# WOODMEN FRONTAGE ROAD TURN LANE

## PUBLIC IMPROVEMENT CONSTRUCTION PLANS

PCD FILING NO. CDR-21-18

PUBLIC IMPROVEMENT CONSTRUCTION PLANS  
FOR  
WOODMEN FRONTAGE RD. TURN LANE  
CHALLENGER COMMUNITIES, LLC

C2.2

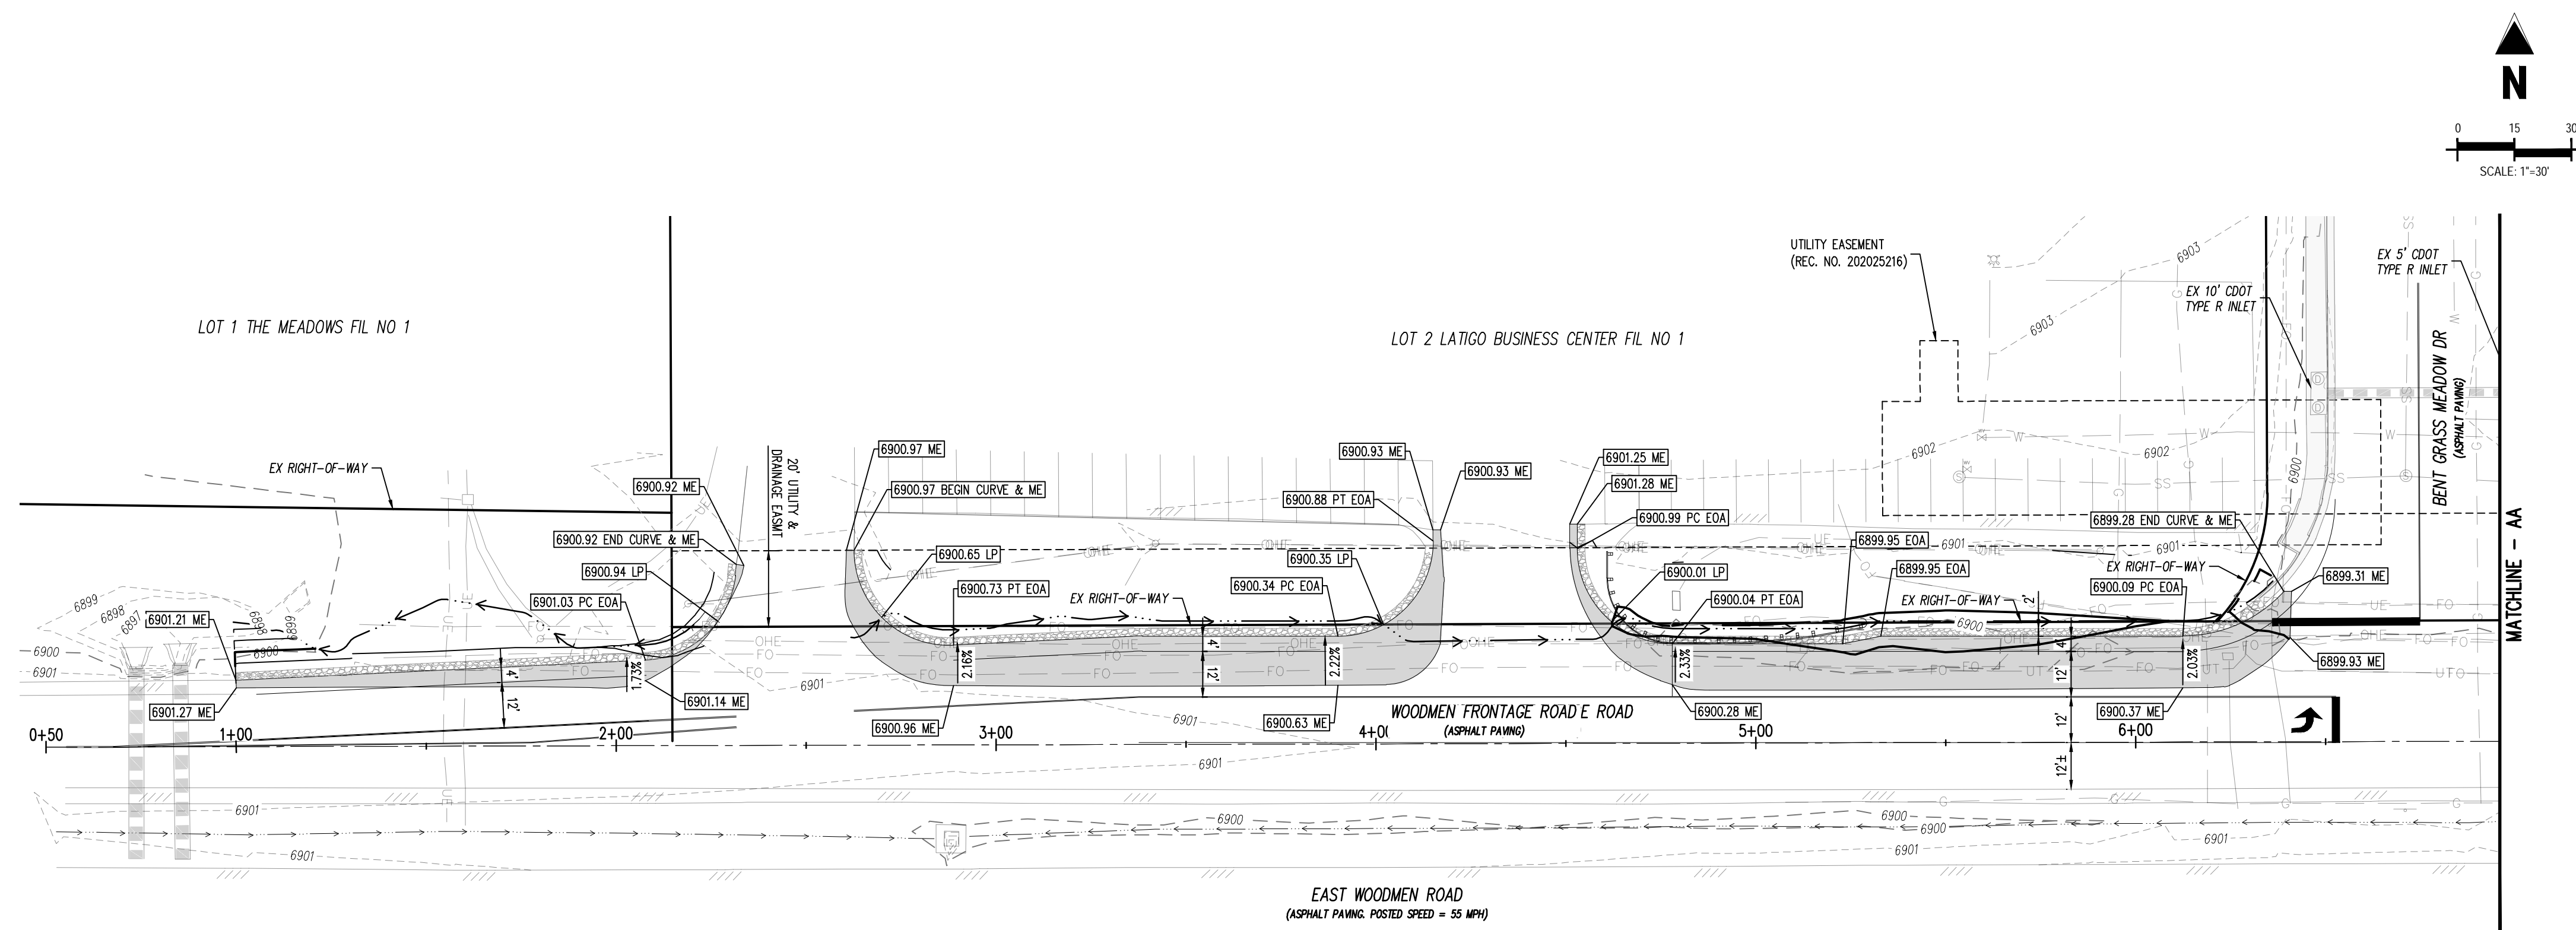
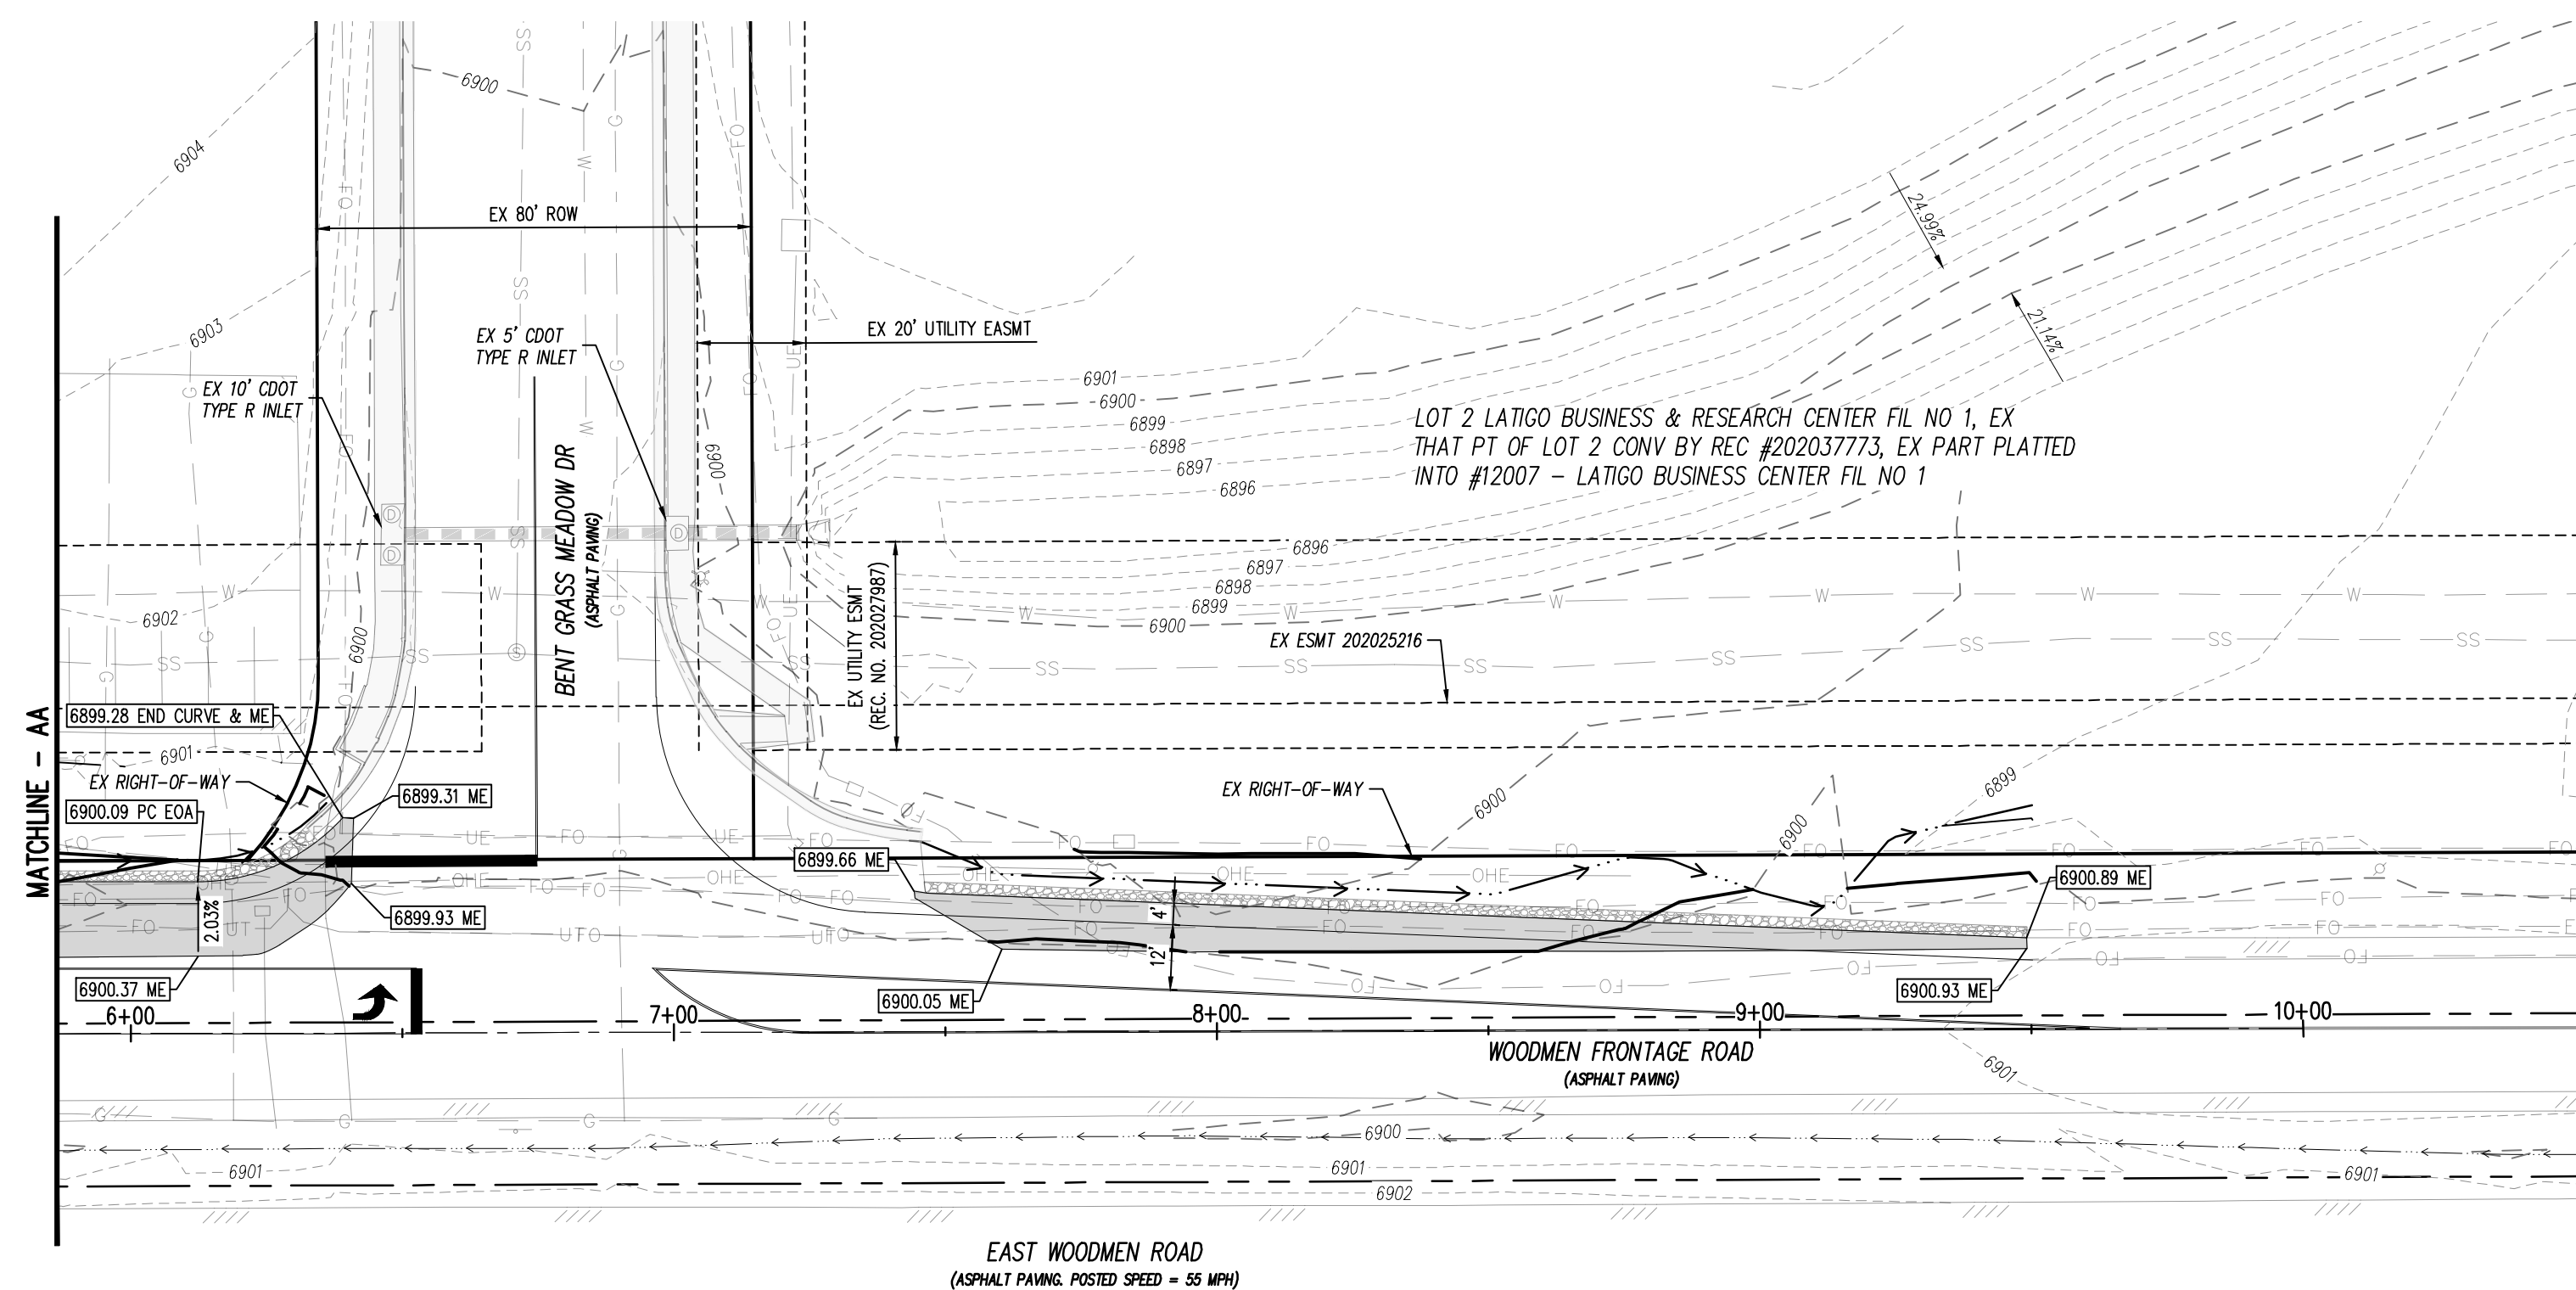
use standard EPC  
8' cross pan

REVISED TO 8'  
CONCRETE CROSS PAN

C2.3

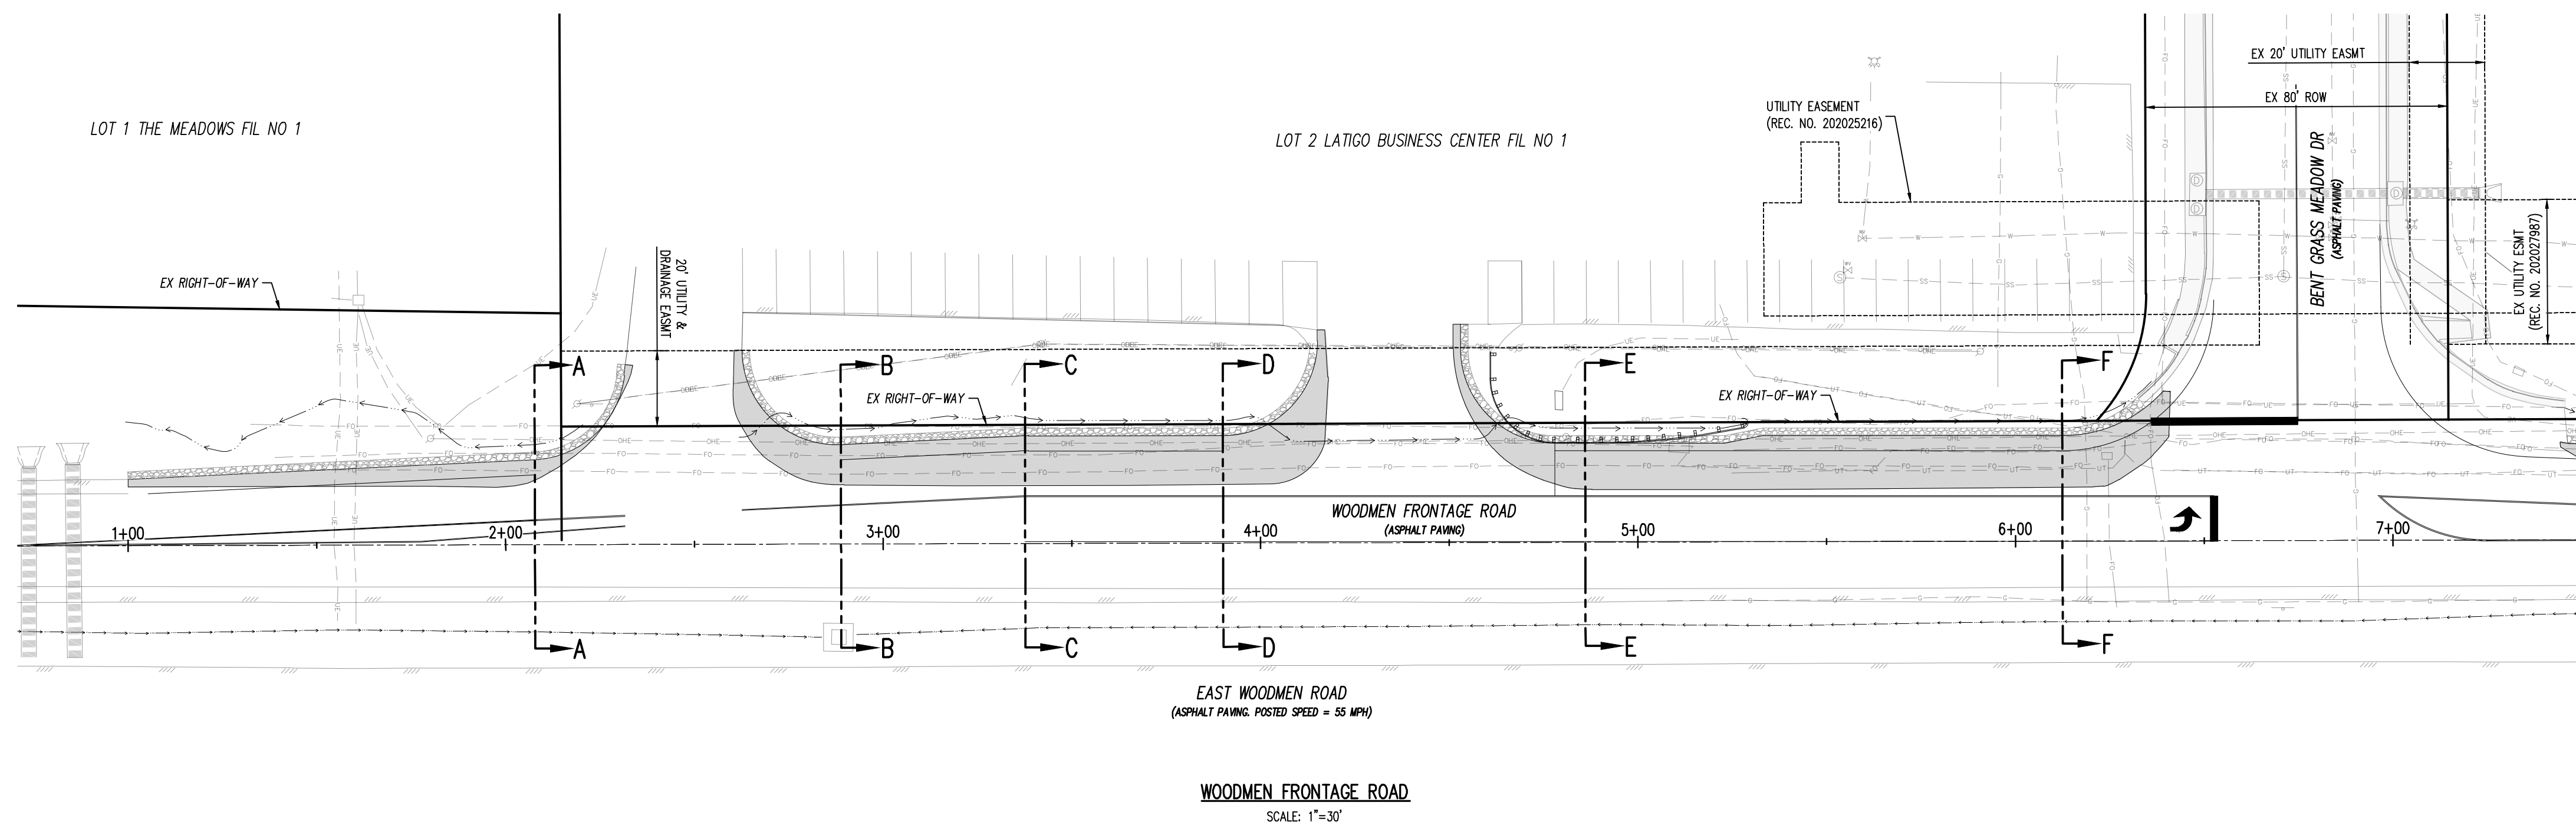
Include location of ROW/Property & easement lines in sections.

ADDED ROW, PROPERTY LINES AND EASEMENT LINES WHEN APPLICABLE. MANY EASEMENTS LIE OUTSIDE LIMITS OF SECTIONS.
